Hunter Environment Lobby Inc.

Additional Submission of Objection

Integra Mine Complex Modification 4
Biodiversity Offset Strategy
08_0101 MOD 4 and 08_0102 MOD 4

Figure 5: Existing Biodiversity Offset Areas

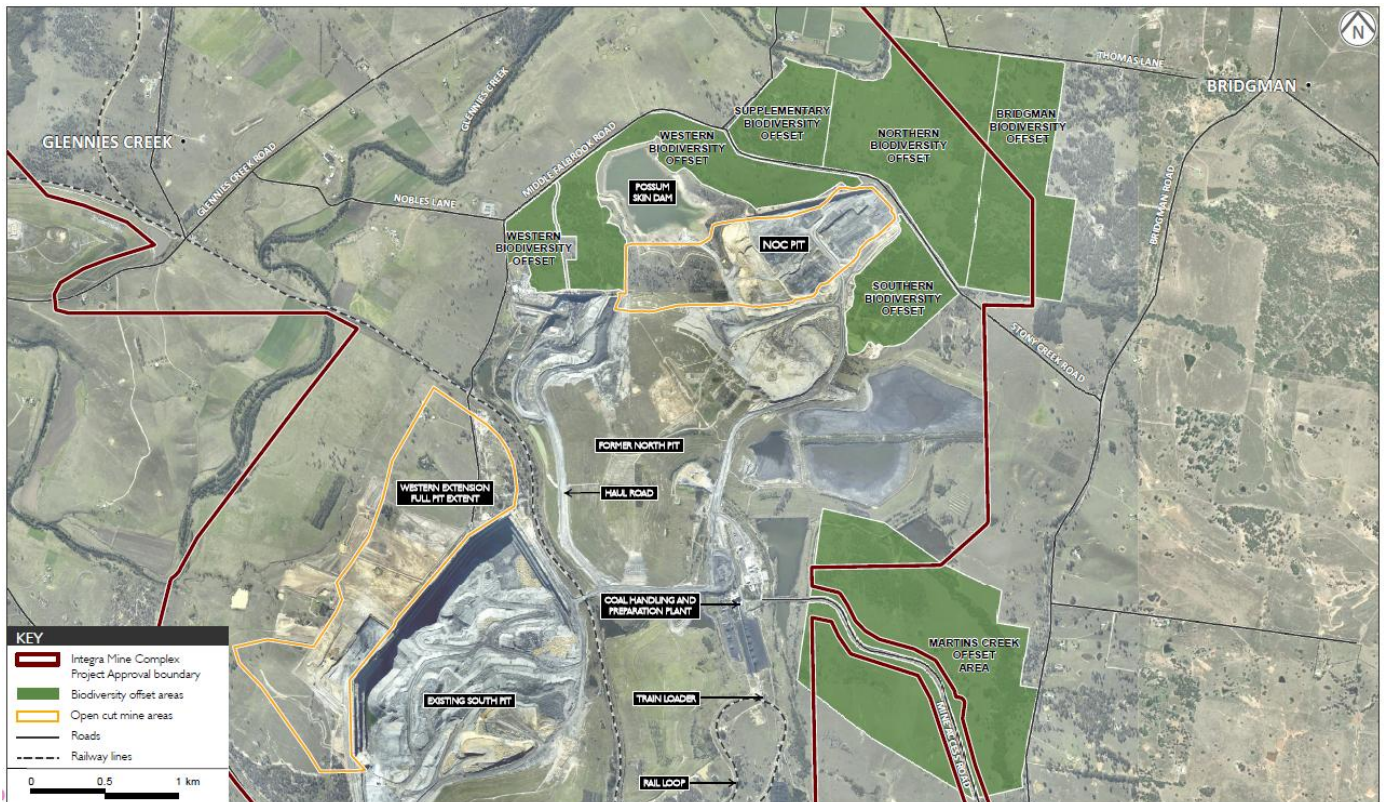
The proposal to remove the entire western and supplementary biodiversity offset areas, part of northern, southern and Martins Creek biodiversity offset areas will cause the loss of 176.8 ha of approved biodiversity offsets.

These areas include 11 ha of Central Hunter Ironbark-Spotted Gum-Grey Box Forest EEC and 3.7 ha of Swamp Oak Floodplain Forest EEC that may be exposed to clearing in the future. This impact has not been clearly identified in the assessment report for Modification 4.

The revised Biodiversity Offset Area, while increasing the area of threatened species habitat, does not include any further protection for these EECs.

The final outcome for the northern, southern, Bridgeman and Martin's Creek biodiversity offset areas is not described.

HEL is concerned that these areas, particularly the remaining northern and southern biodiversity offset areas will be subject to a further modification. This is unacceptable.
